Subject: RE: Planning Consultation on: BE/40/22/PL

Further Engineers Comments Regarding Surface Water Drainage

Registered: 6th April 2022
Site Address: Former Bartons Infant School Romney Broadwalk Bersted PO22 9BH
Grid Reference: 492553 100908
Category: Plan Applicat'n
Description of Works: Demolition of former school building and erection of 21 No. new dwellings and associated car parking, cycle parking and landscaping. This site is in CIL Zone 4 (Zero Rated).

filename: w:\1444 wsc - lovell\jvhedcad\2 north bersted\1444-hed-dr-02-002-003 hard & soft landscape plans p01.dwg; printed on:2022-03-31 on iso full bleed a3 (420.00 x 297.00 mm) @ 100% of original scale

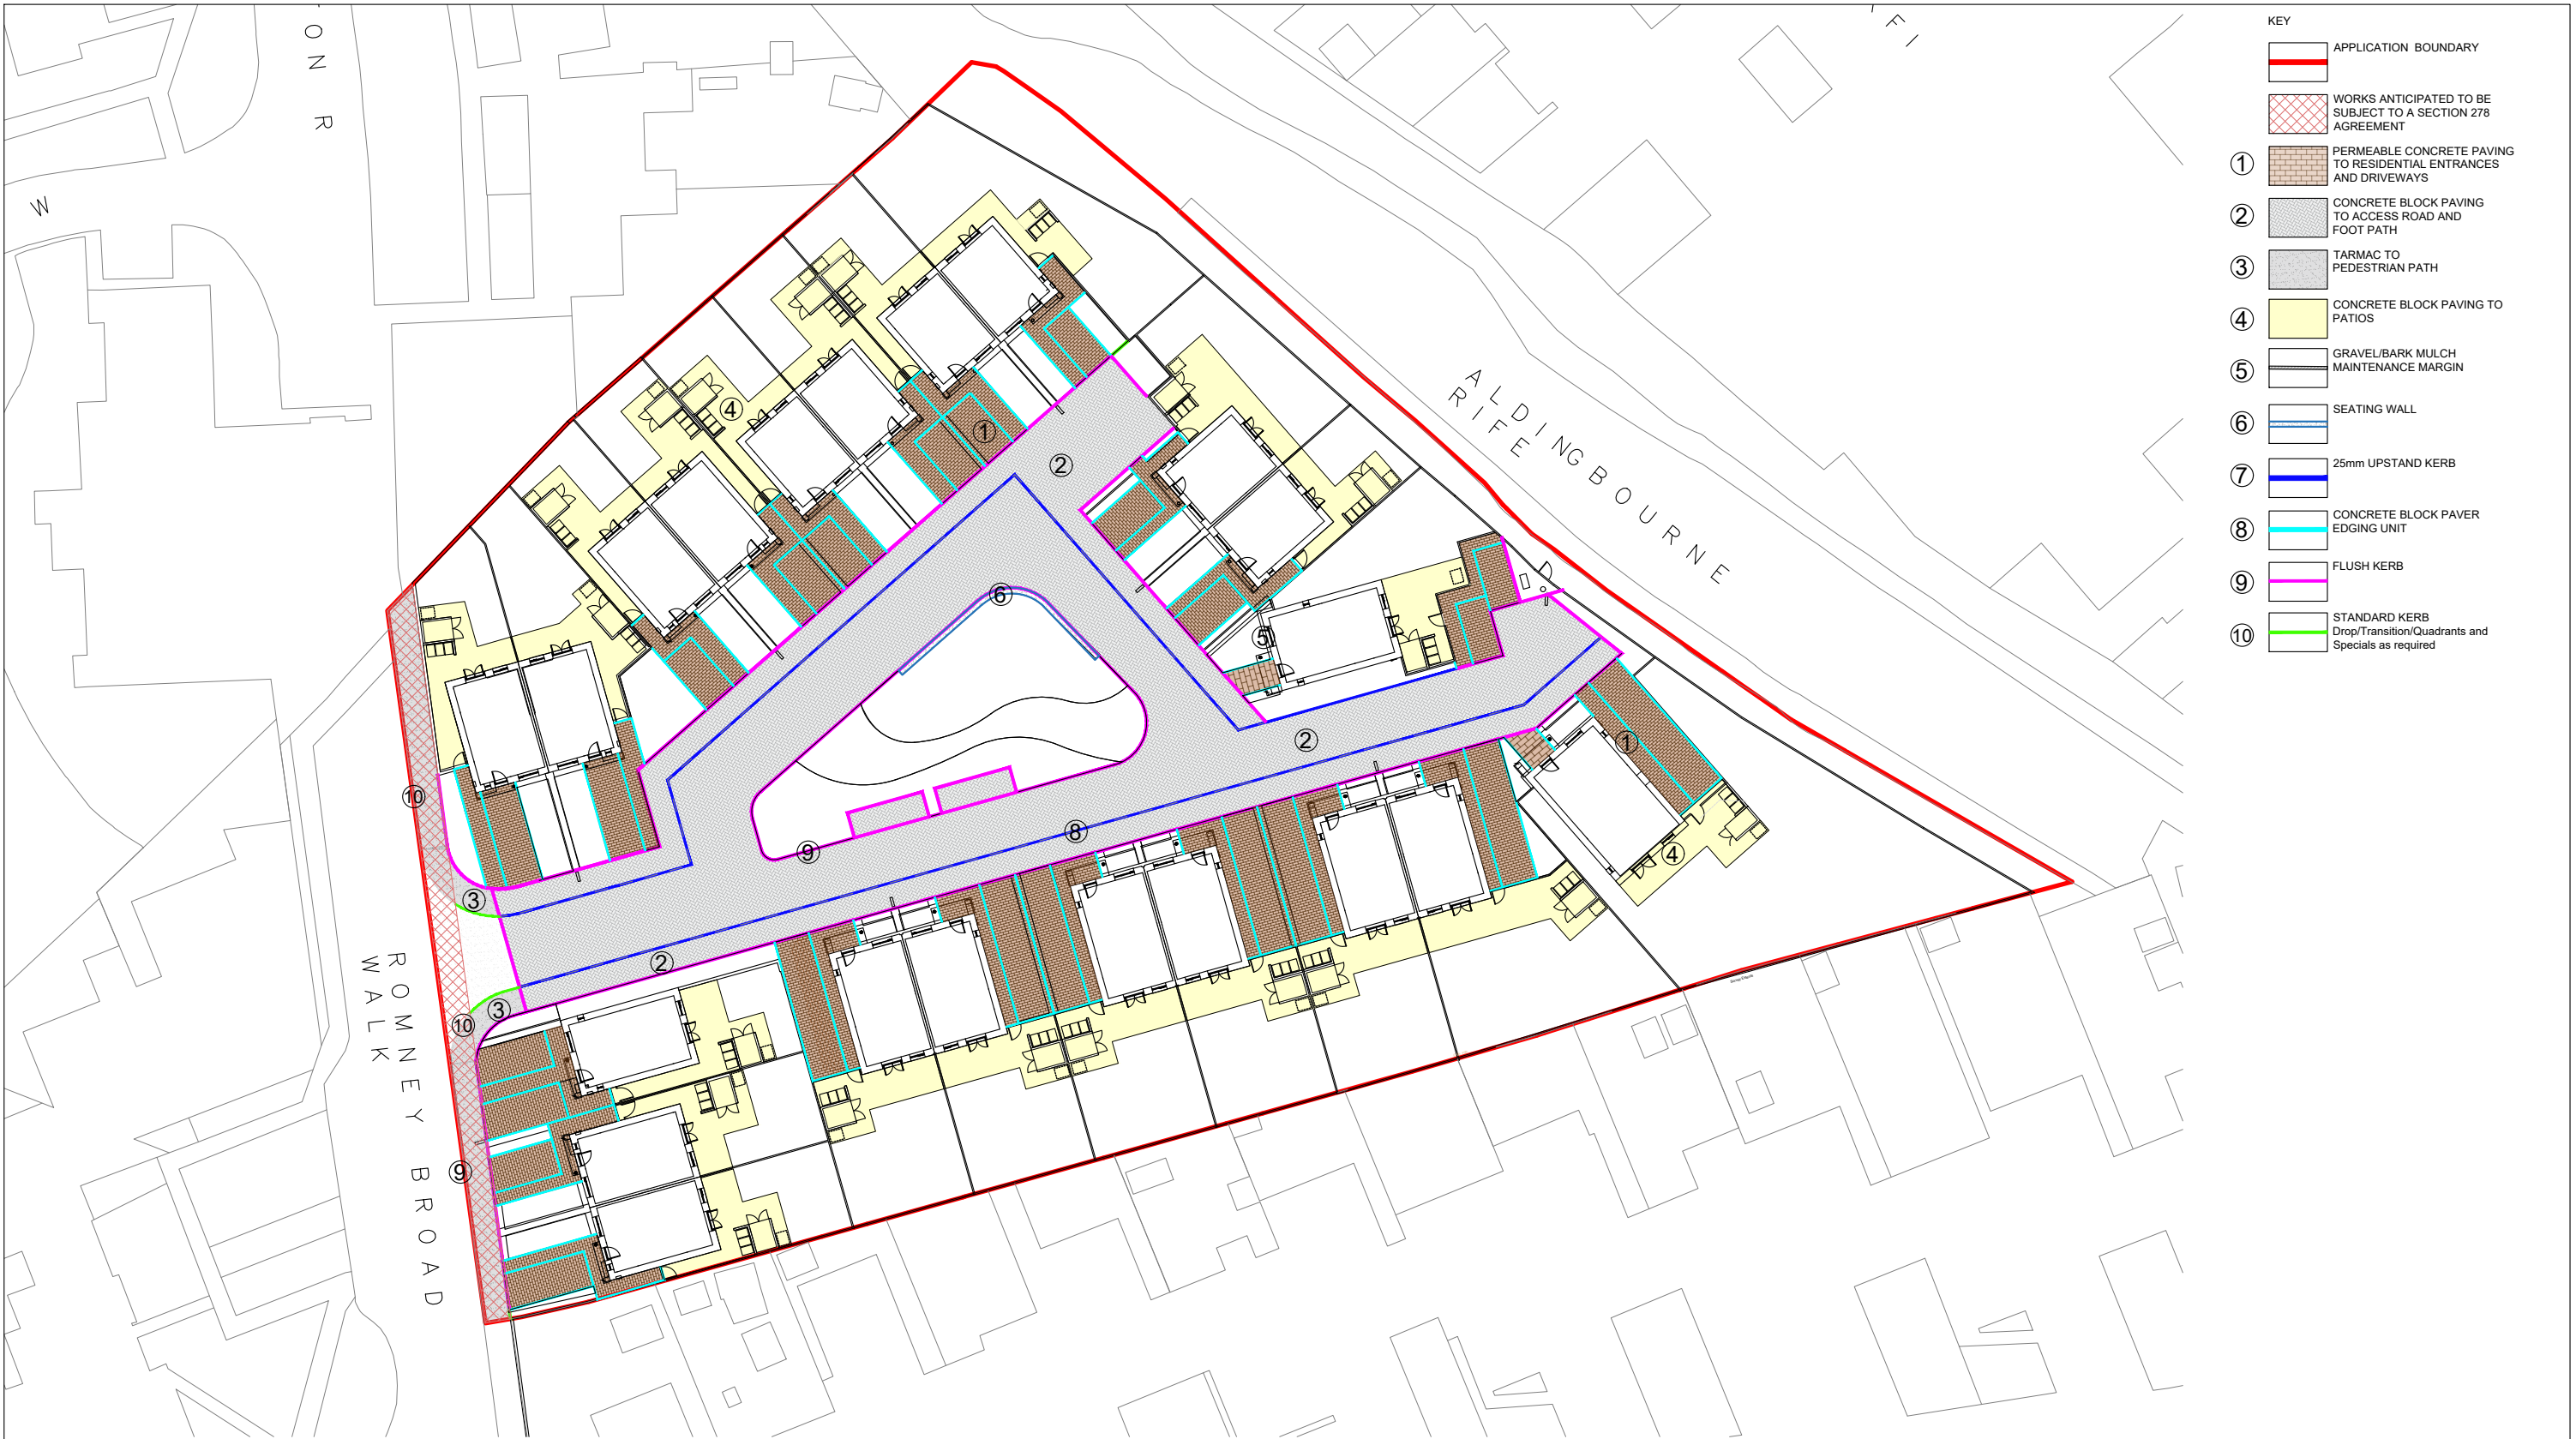
The current landscaping design proposes one Red Oak tree and 8 Himalayan Birches planted directed over the area where the attenuation tank and storage blanket are proposed. This is inappropriate – drainage infrastructure and trees must not conflict. Tree roots have the potential to damage pipes, the tank and blanket liners which can cause groundwater ingress, loss of capacity and connectivity. Furthermore the location of substantial drainage apparatus within 0.3m of ground level is likely to inhibit the growth of the proposed trees – please consult the landscaping officer in this regard.

There also appears to be a proposed Quercus Rubra (Red Oak) located directly over the proposed outfall pipe east of plot 11. It is likely that this tree will need to be removed or relocated in the landscaping proposals.
